Application for Outline Planning Permission for erection of ten dwellings with access from Hoe Lane. Resubmission of Y/20/18/OUT - This is a Departure from the Development Plan

Land south of Hoe Lane Flansham

Thank you for your internet representation made on 24th October 2019 which has been recorded as '**an objection**' with the comments as follows:

Visibility Splays
and Swept Path Analysis

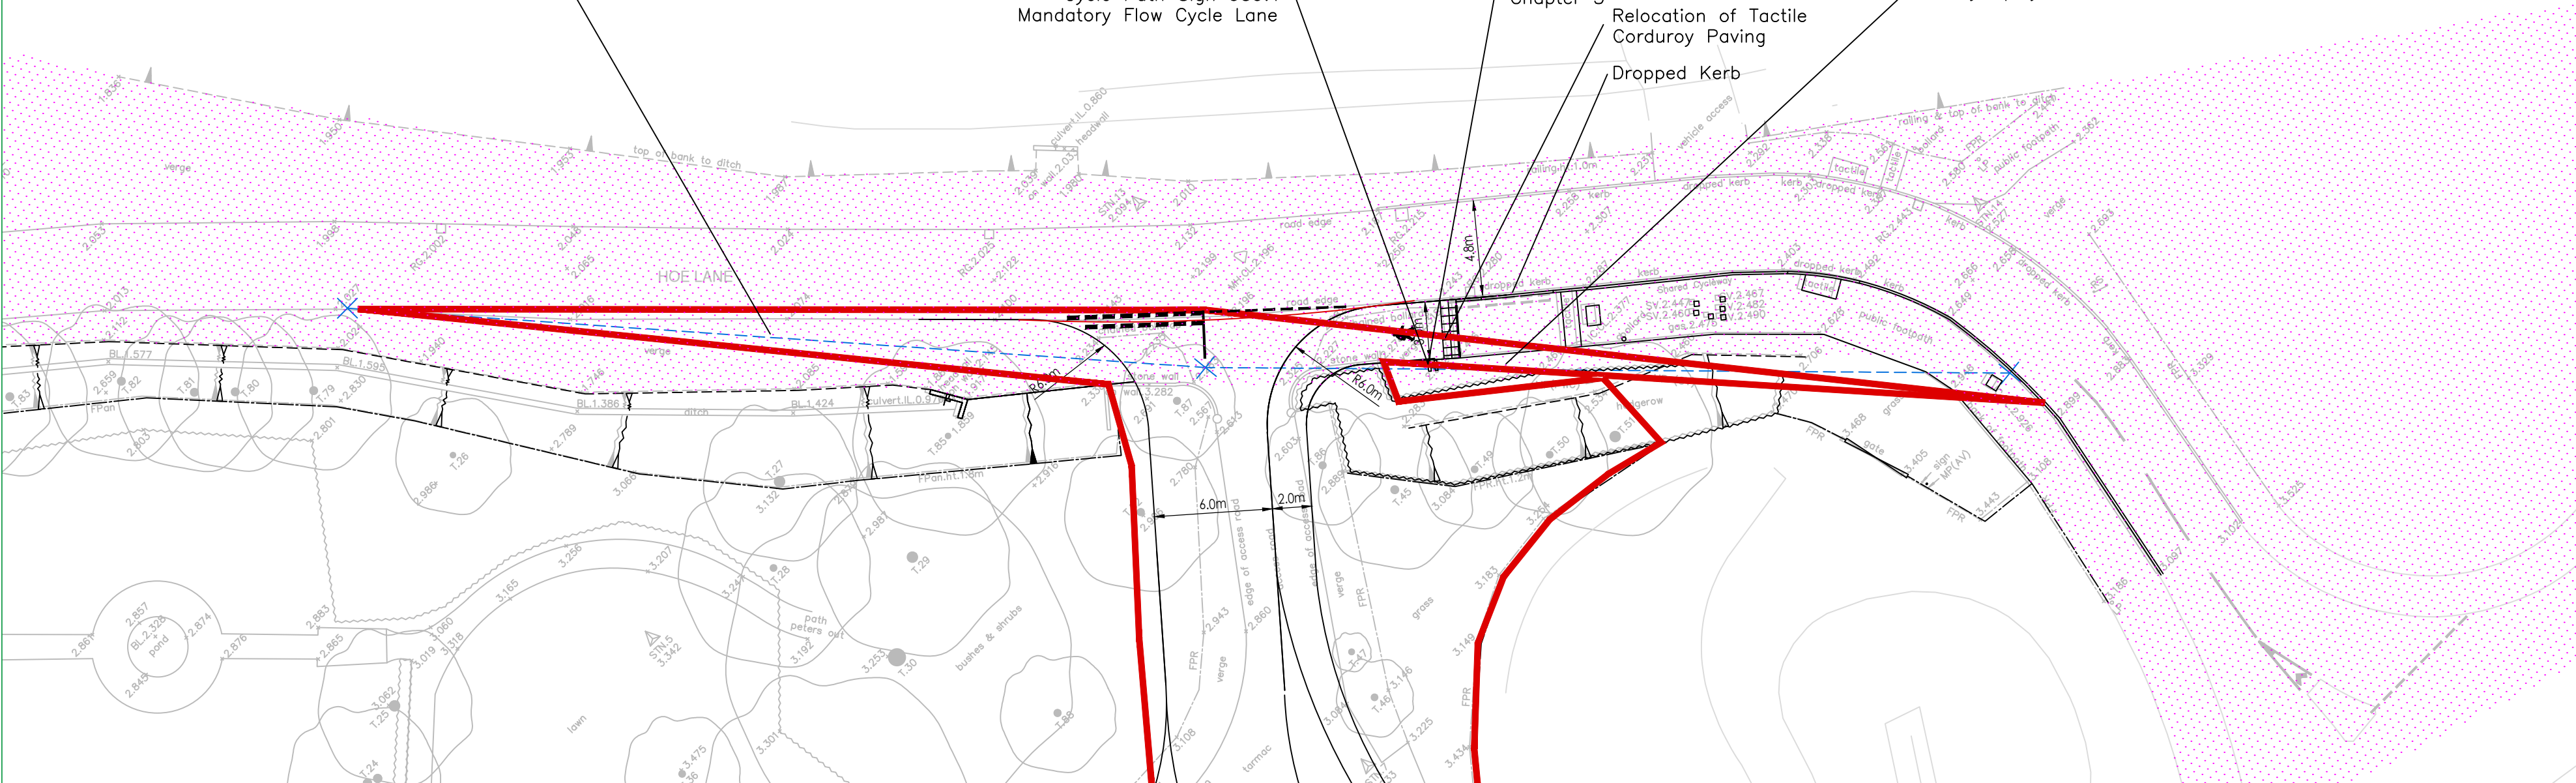
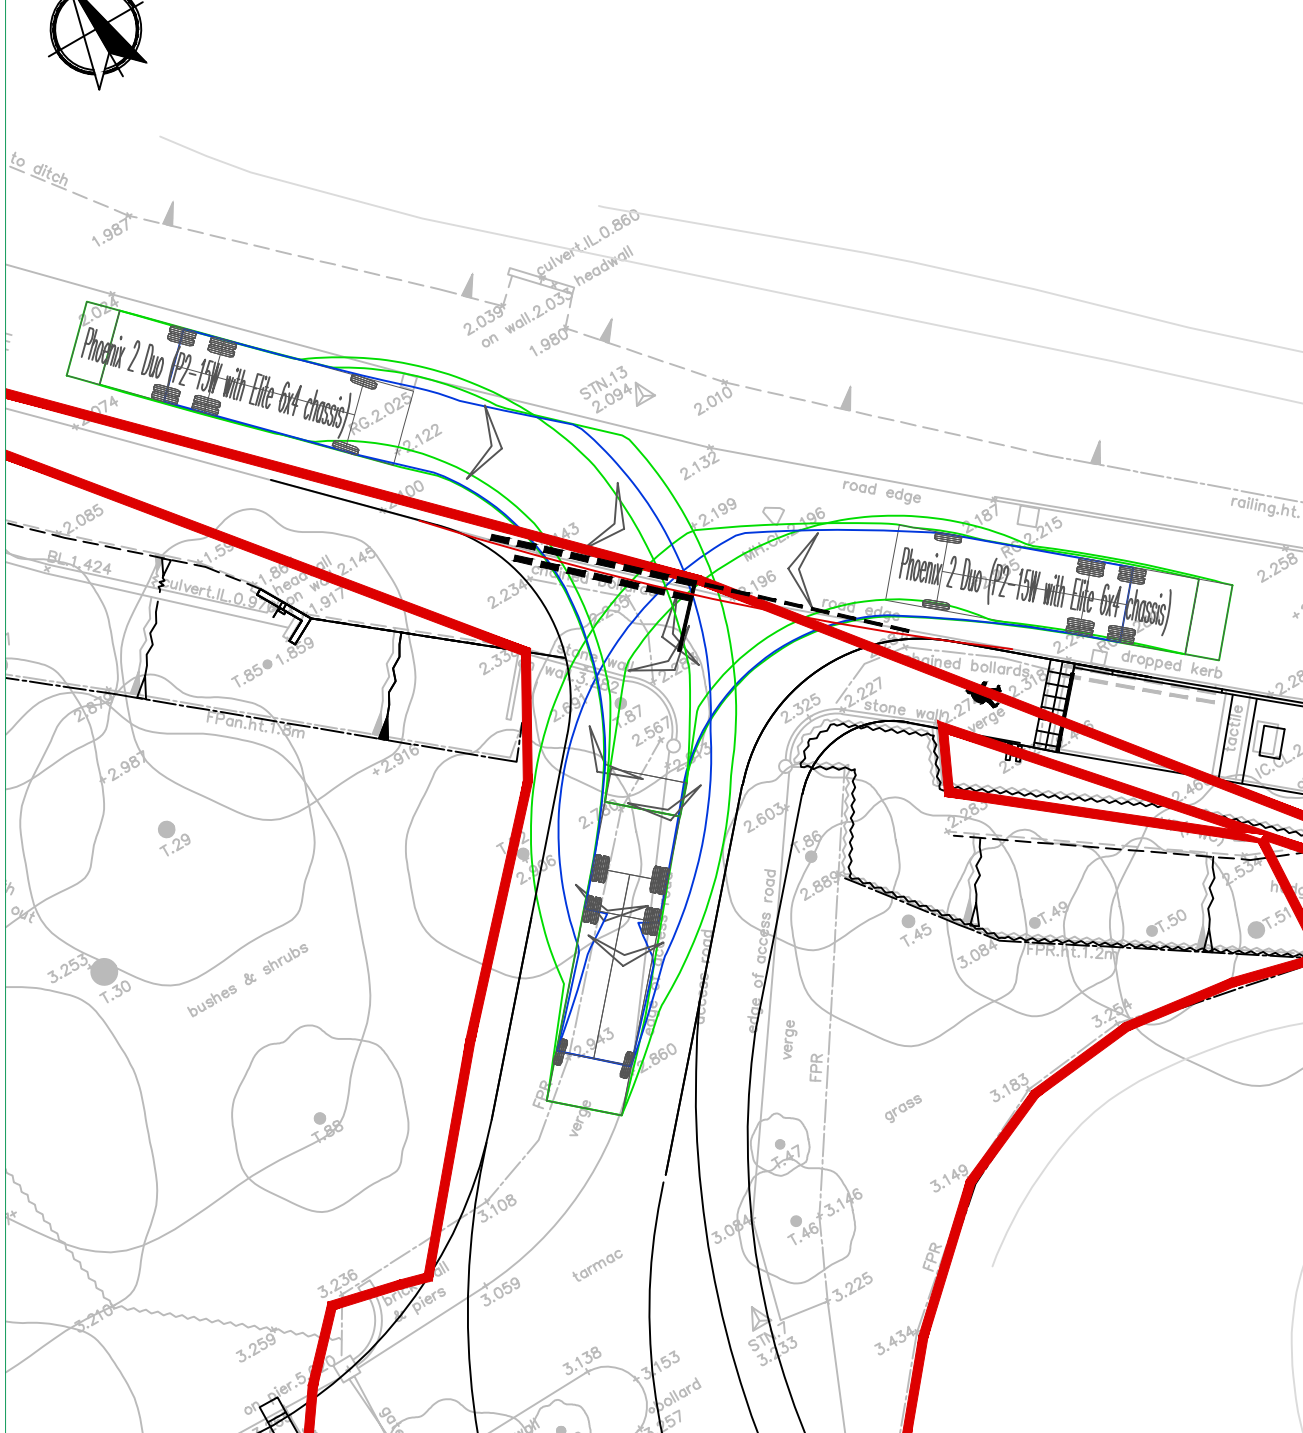
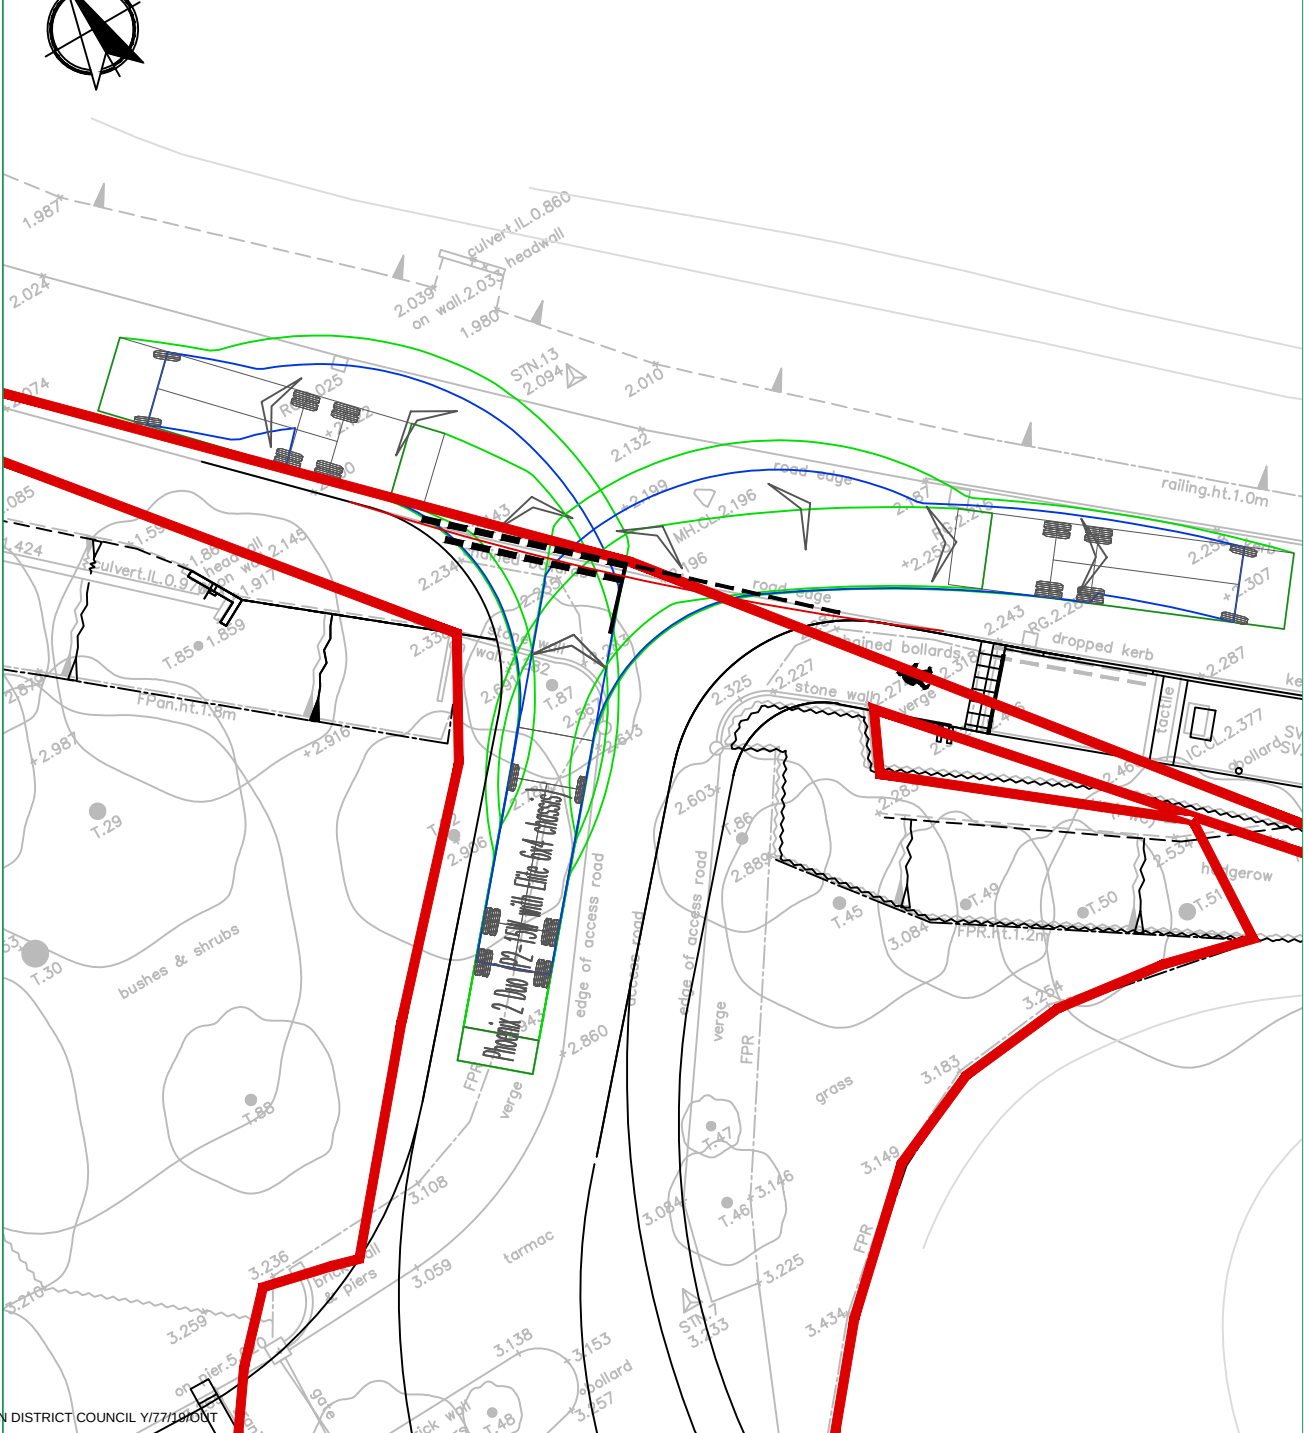
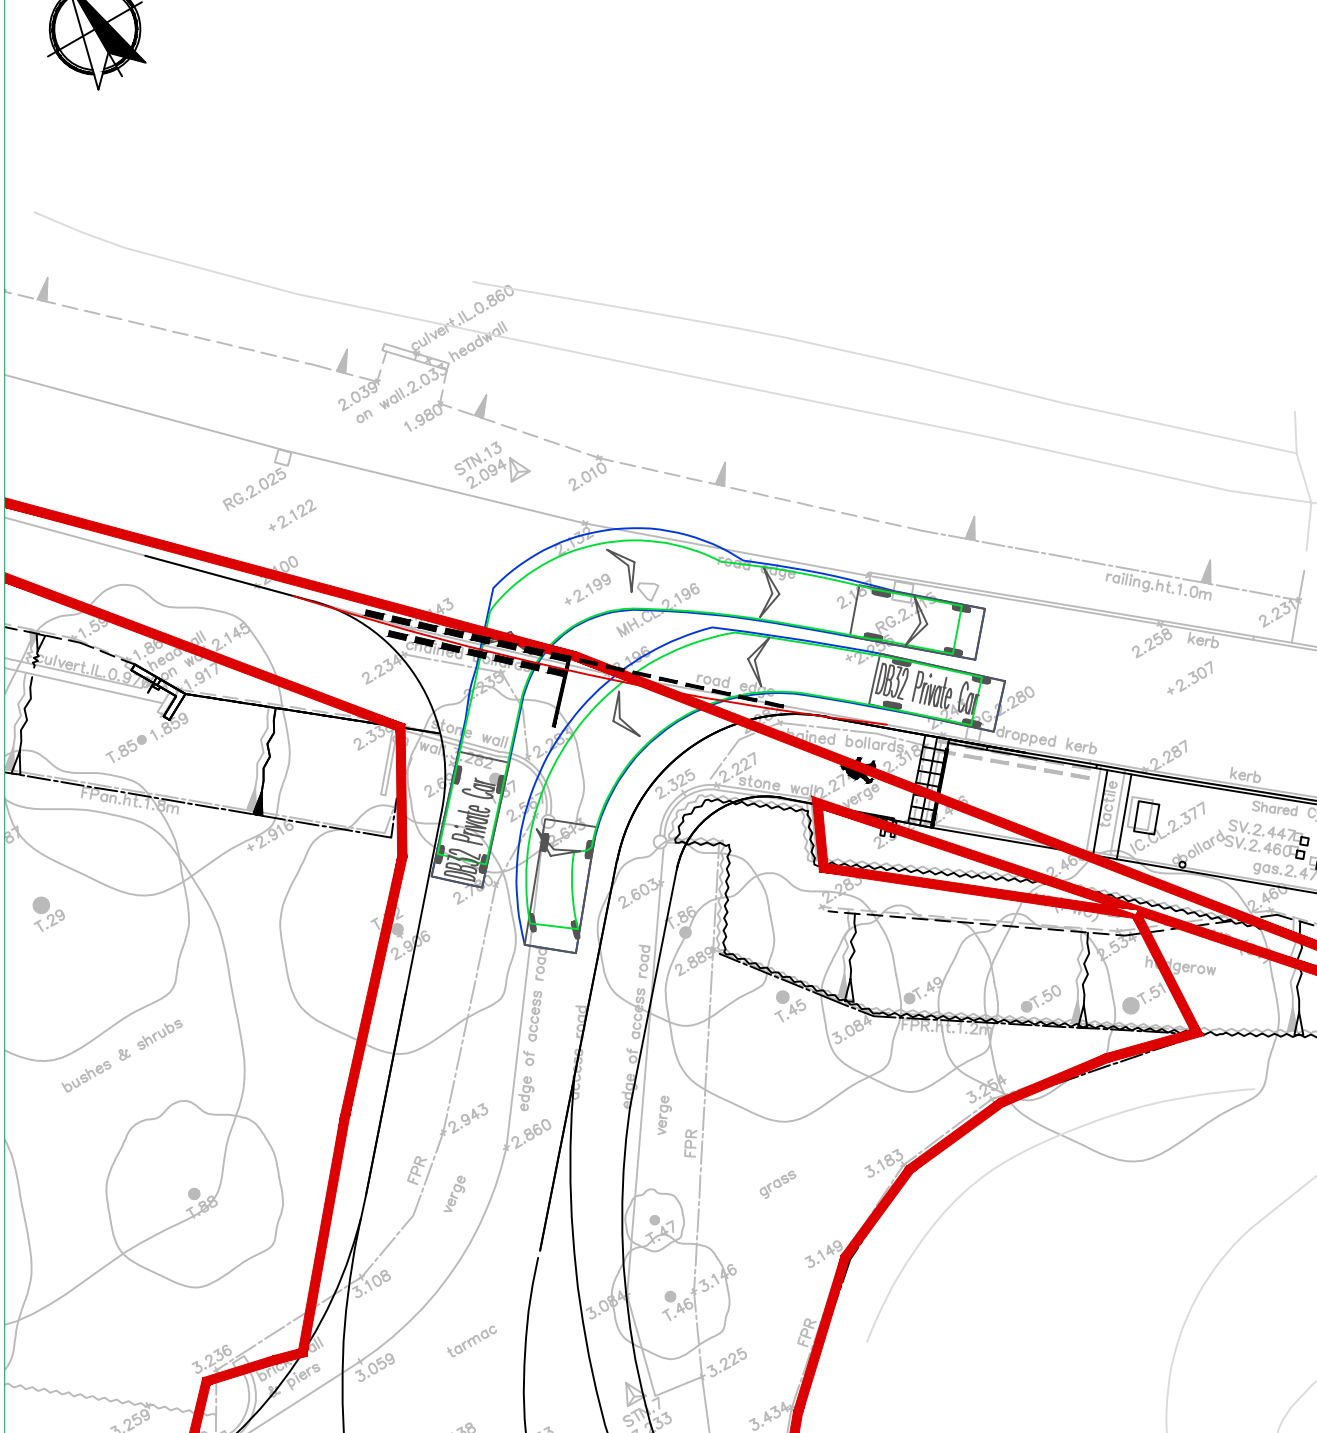
*The additional traffic that would be generated by the new dwellings, would be concentrated on a very narrow, dangerous section of the lane. The proposed access road is situated north of a blind bend. The bend is too narrow for two vehicles to pass without due care and attention, and frequently, larger vehicles/vans/lorries, mount the pavement/cycle path to get by, putting pedestrians and cyclists at risk.*

*The swept analysis diagram is not relevant to this new design and has not been revised. There appears to be no provision within the site, for larger vehicles to turn round.*
